DOC19/65361-2: EF13/3919

6 February 2019

**Stockton Sand Quarry (DA 140-6-2005)
Modification 3- Comments from the Environment Protection Authority**

**Figure 4.4** Cross section, showing existing and proposed pit extent/design (sections 1 and 2)

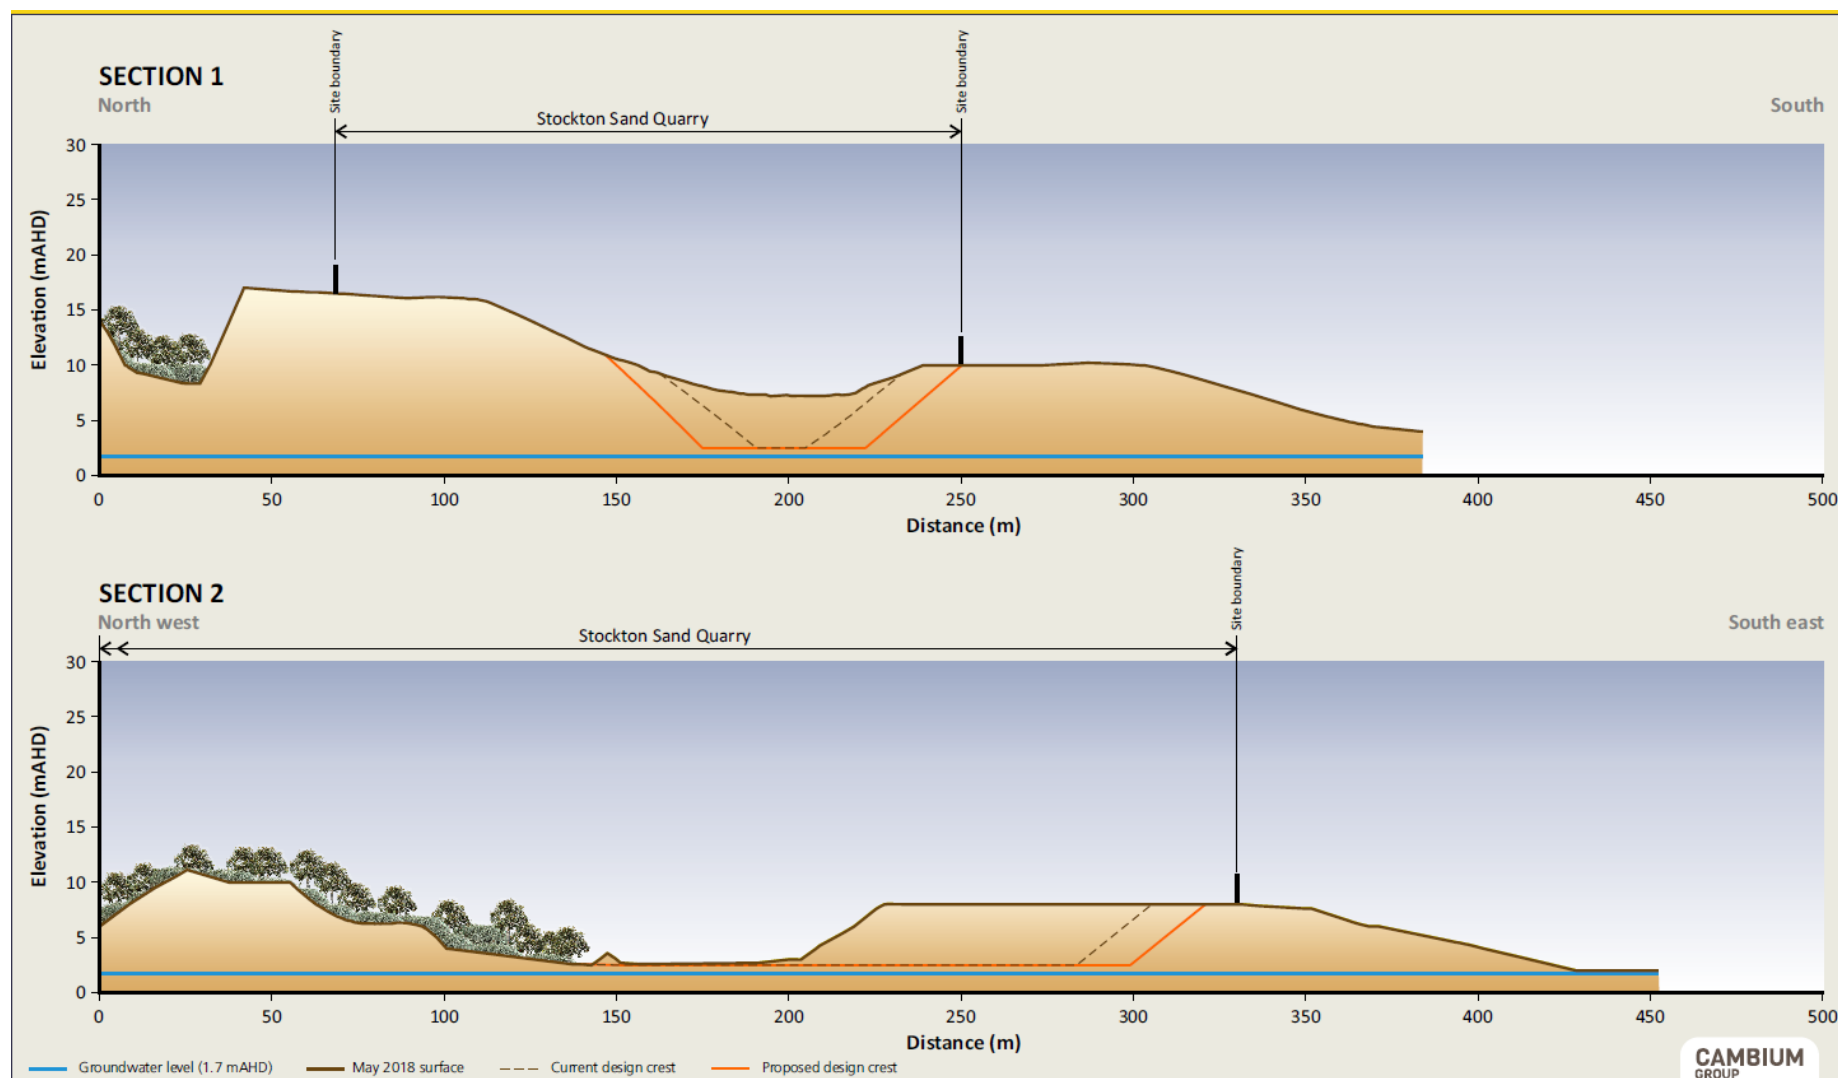
- the proponent must not extract sand within 0.7 metres of the maximum predicted groundwater level at the premises at any time.
- the proponent must ensure that rehabilitation of final landform levels remain one metre above the maximum predicted groundwater level at the premises.
